Our Ref: 25/0973/PCA

RE: Application by Heathrow Airport Limited for an Order granting Development Consent for the Expansion of Heathrow Airport (Third Runway) EiA Scoping consultation.

Title
Figure 5.3: Air Quality Management Areas (AQMAs) around Heathrow

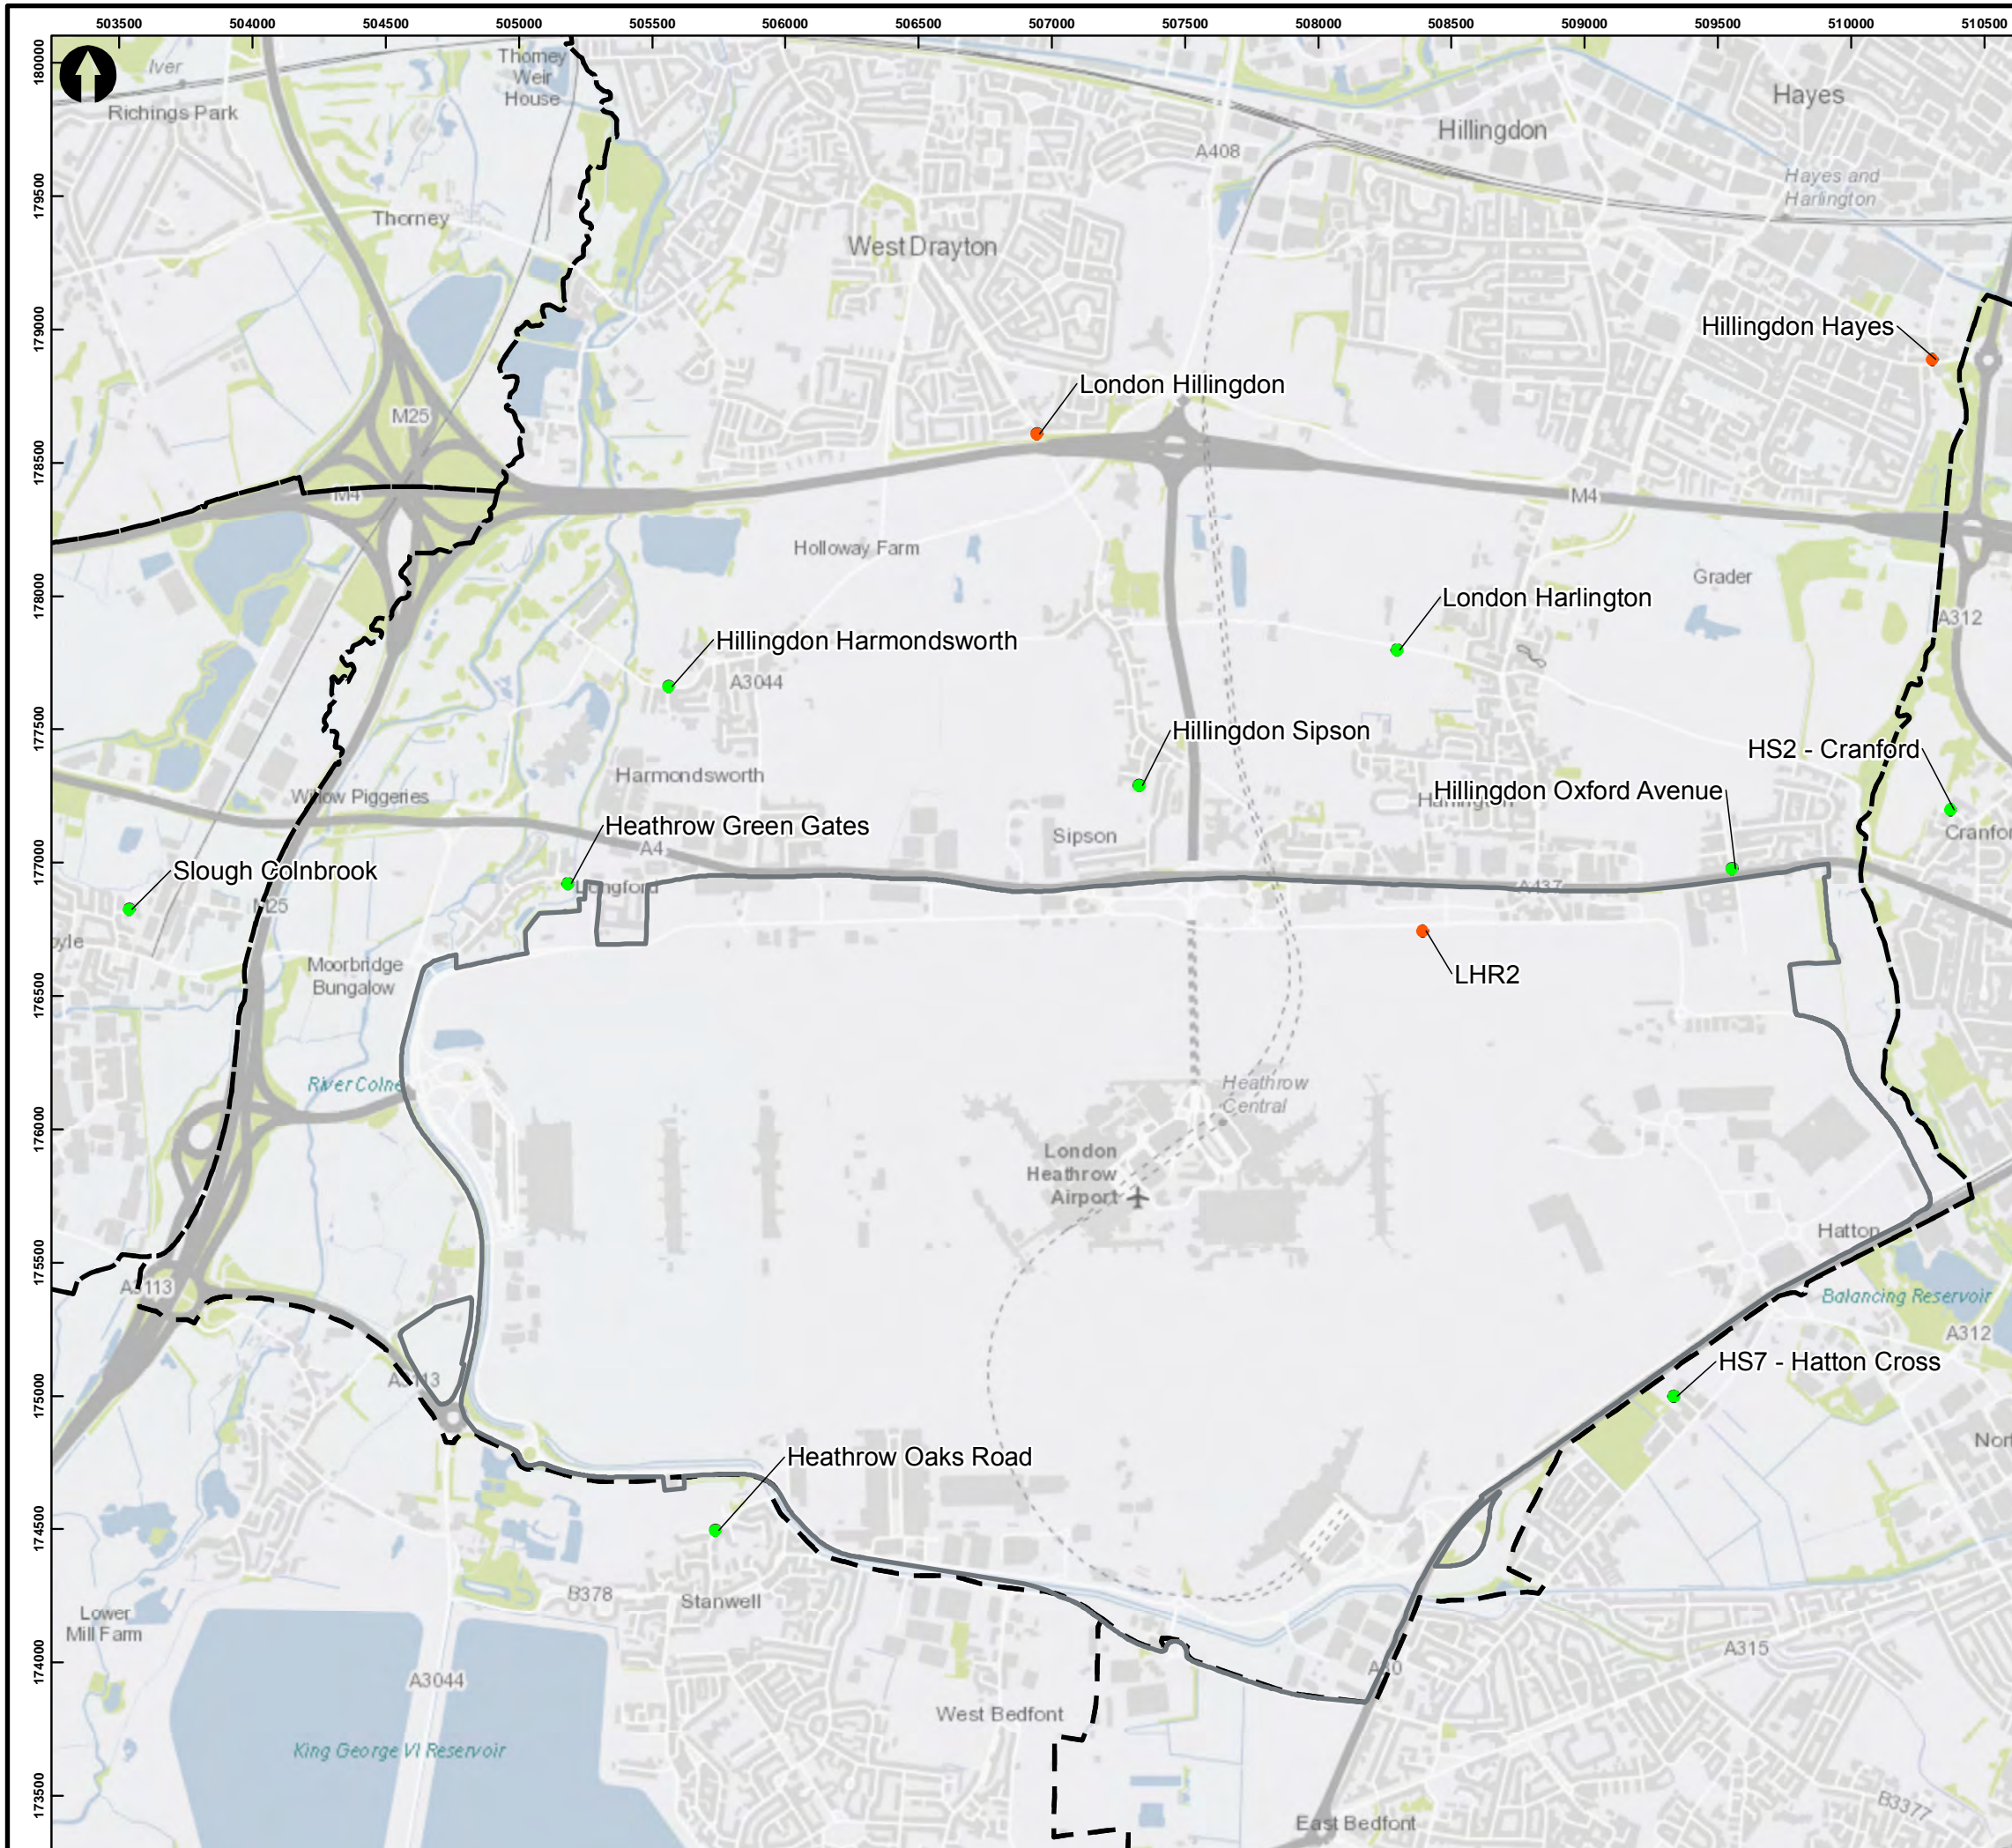
The scope of the Air Quality assessment should also include the AQMA's contained within the Borough that are linked to the air quality implications of traffic accessing and using the strategic road network.

Title
 Figure 6.1: Biodiversity study area

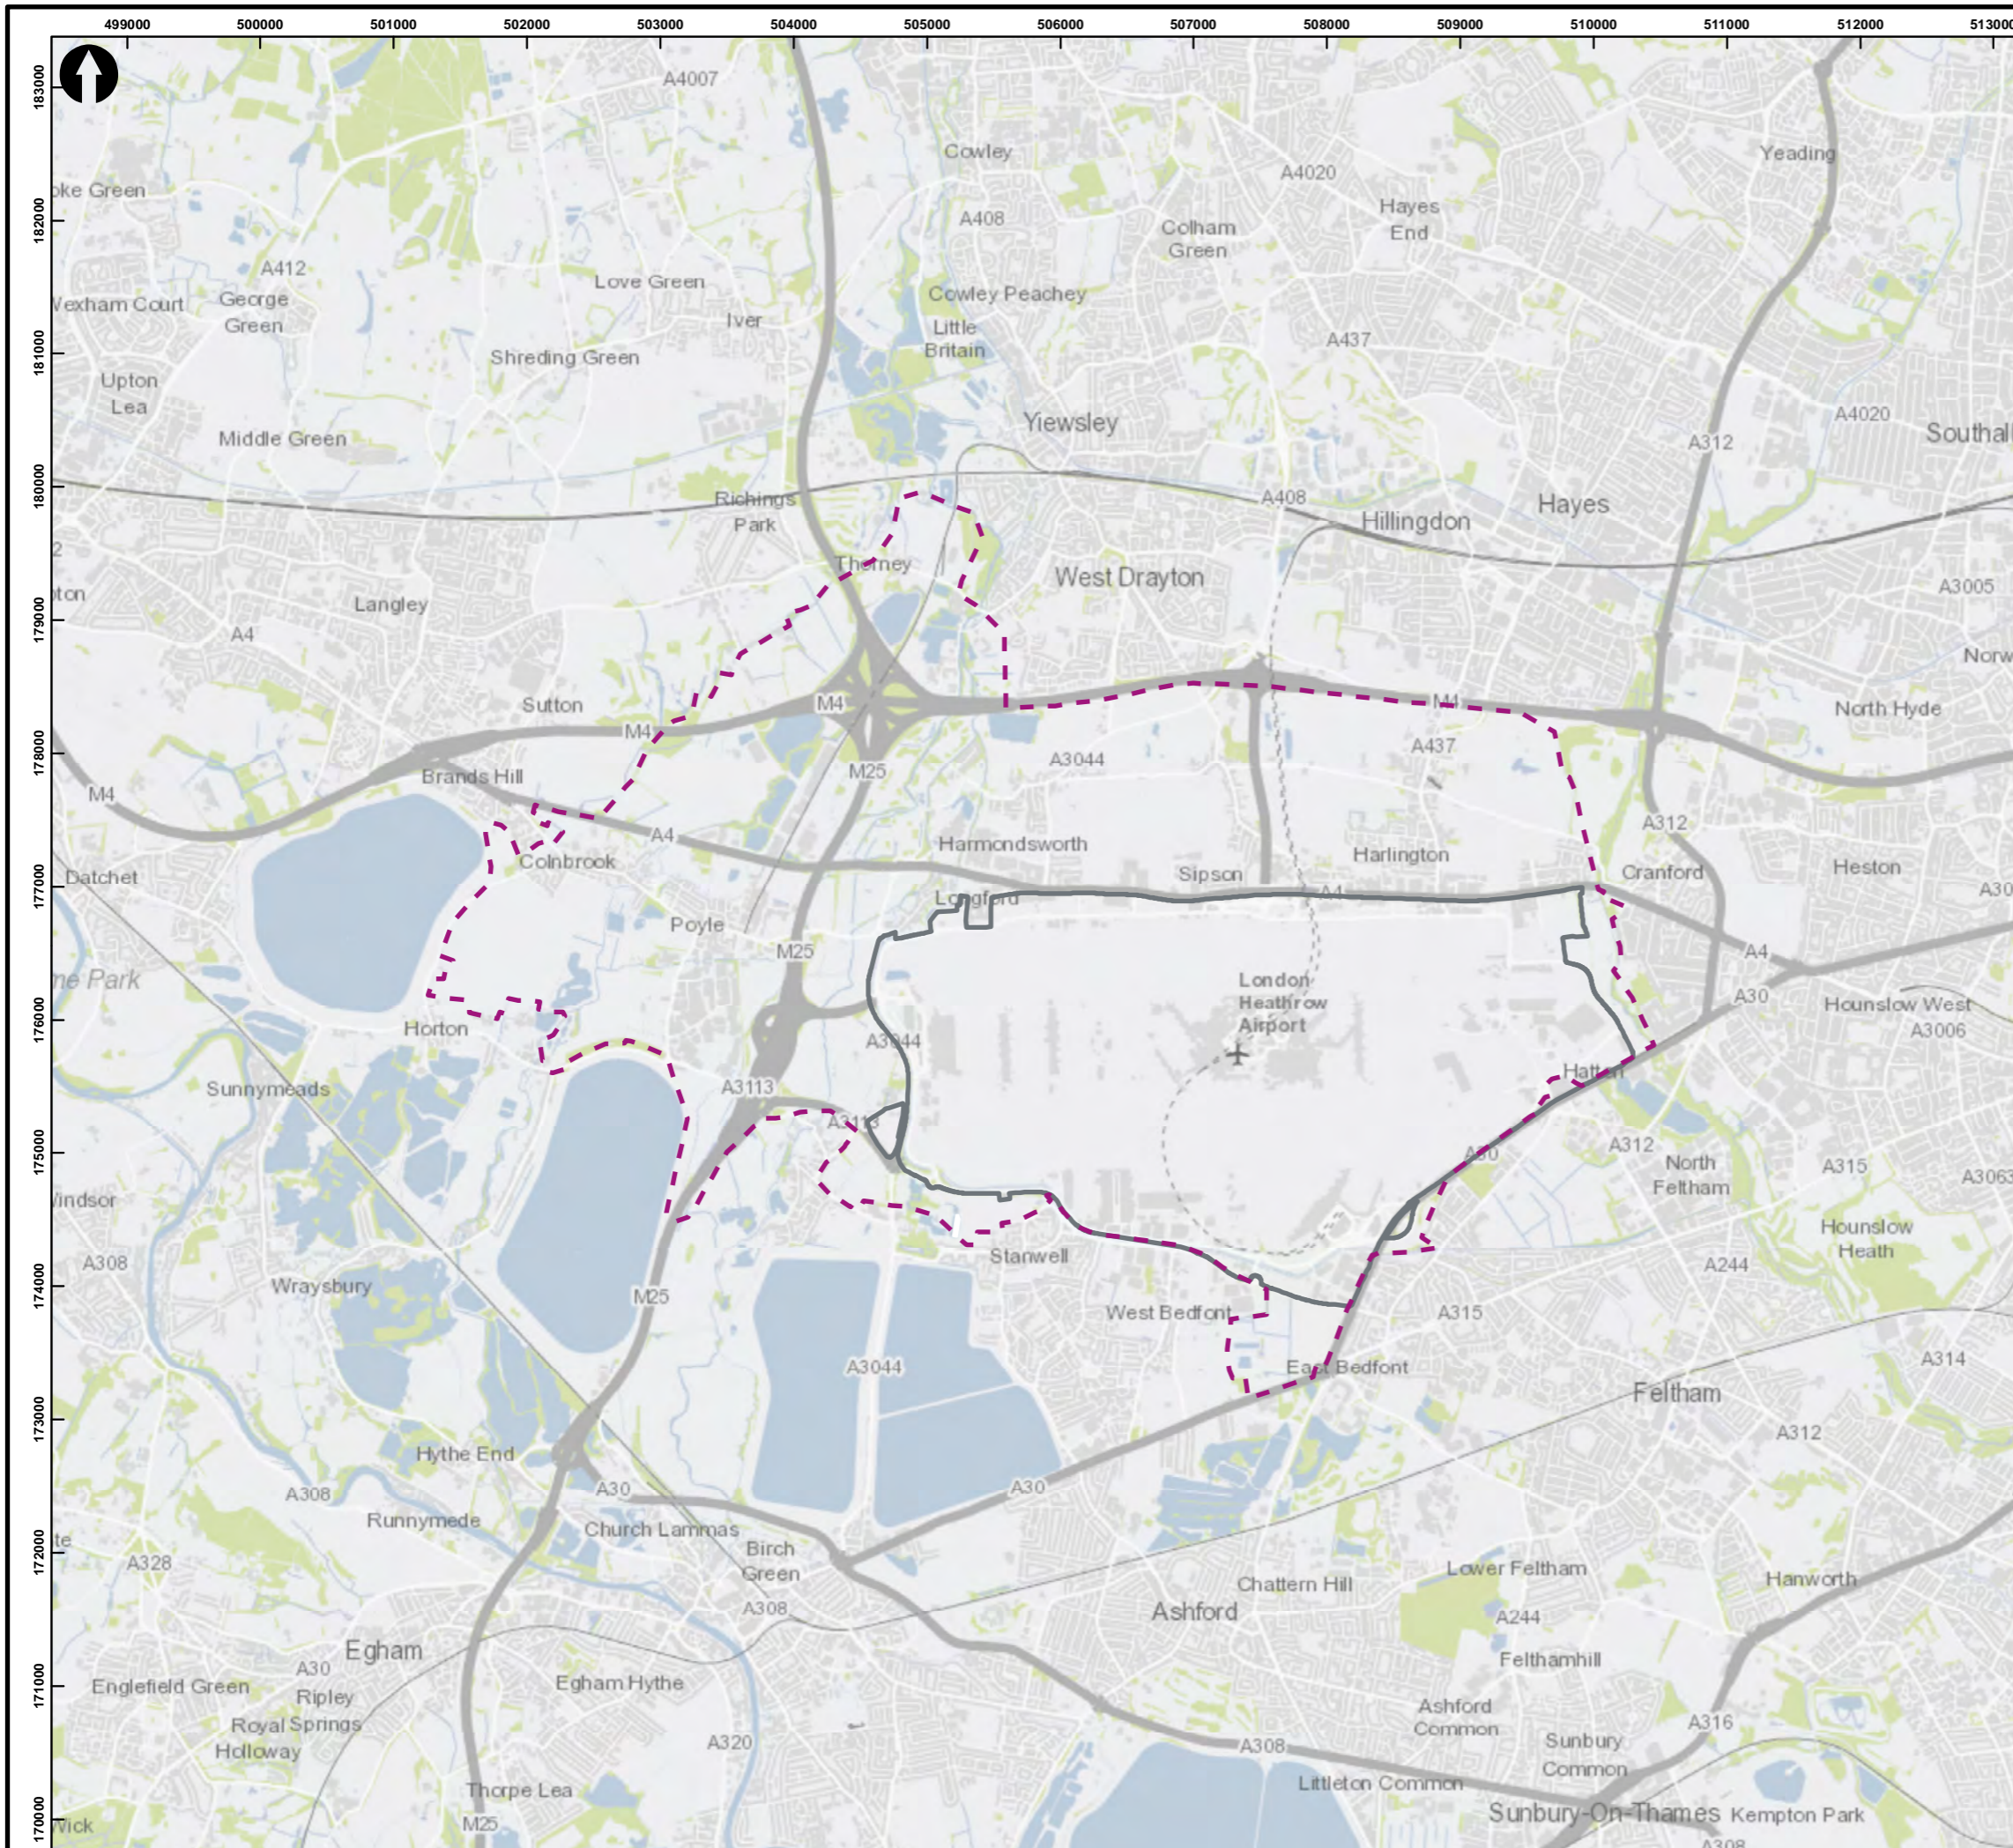
The geographical extent of the study area in respect of Biodiversity also needs to consider the potential air pollution impact associated with traffic movements on areas such as the European Sites (Thames Basin Heath SPA). Any offsetting opportunities may be required to be delivered in Surrey Heath to offset the specific impact in the borough.
